**Re: Meridian Business Park, Lot 13 Engineer Certification  
Engineer's Certification dated 8-21-03, (K10/D43)**

***RE: MERIDIAN BUSINESS PARK, LOT 13, OFFICE WAREHOUSE (K10-D23E).  
DRAINAGE REPORT & PLAN FOR BUILDING PERMIT APPROVAL.  
ENGINEER'S STAMP DATED MARCH 7, 2001.***

C-1

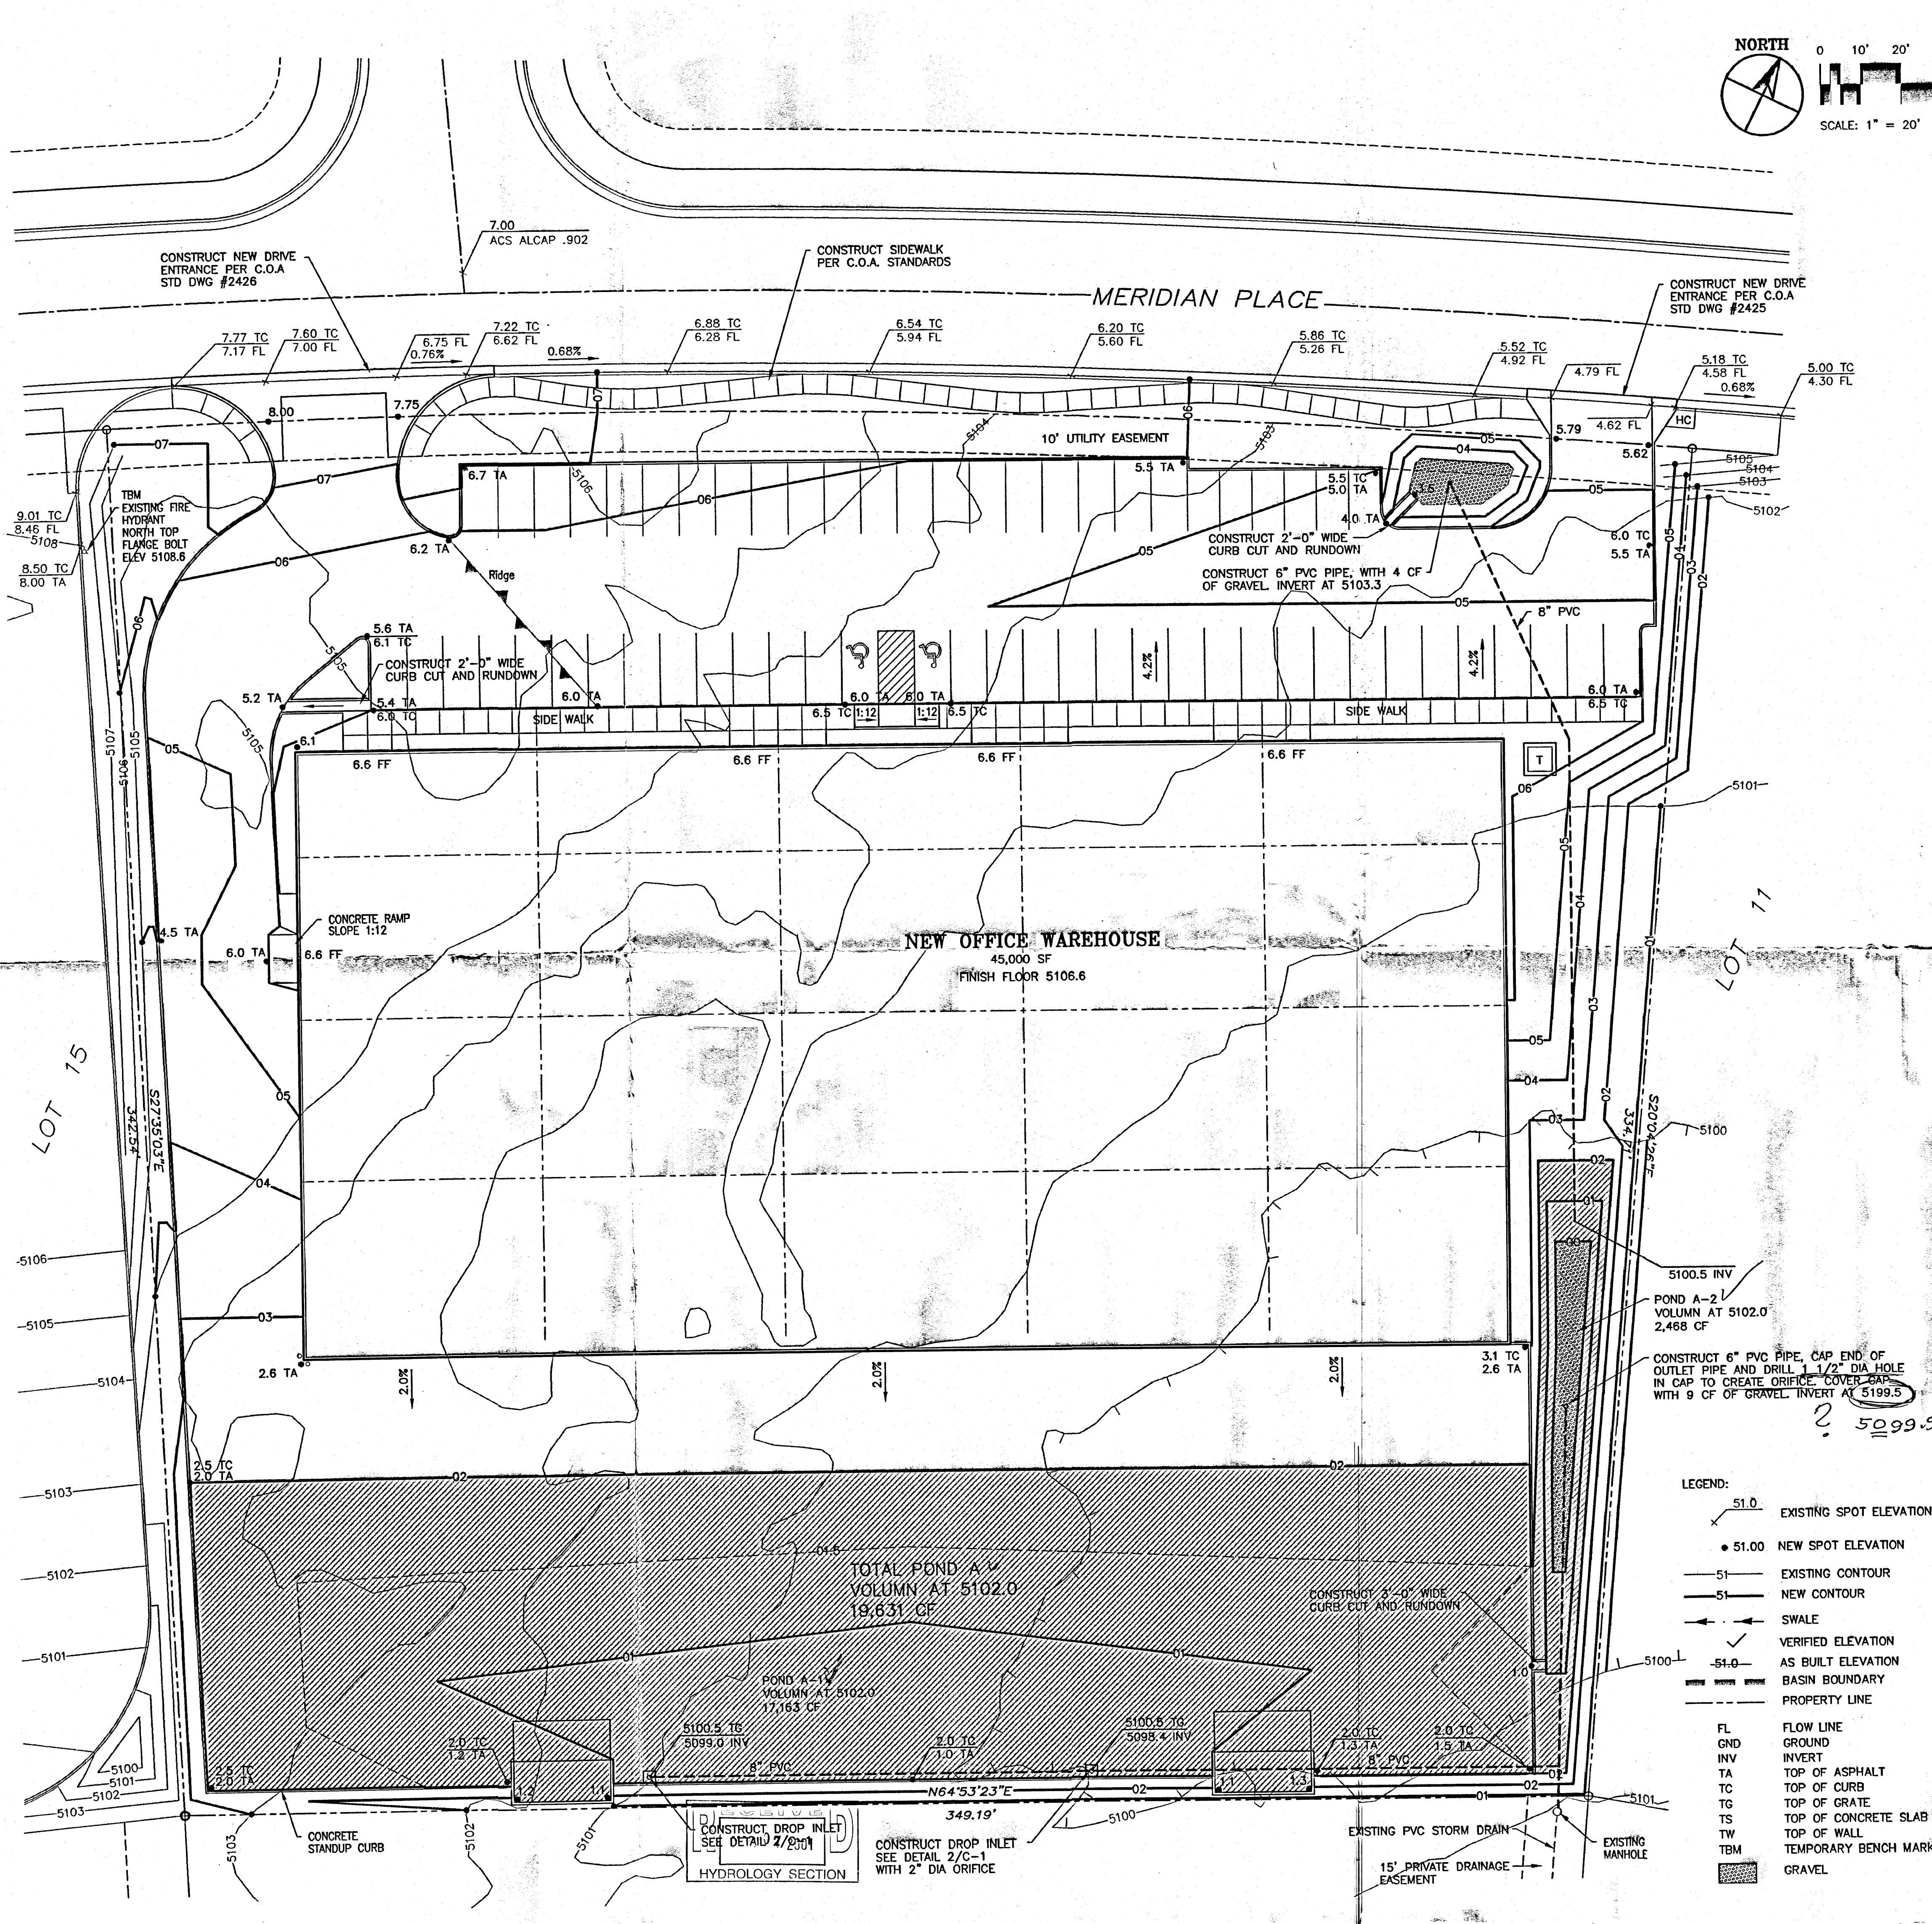
With the base elevation around 5100 feet, the invert elevation at Pond A-2 should read 5099.5 not 5199.5.
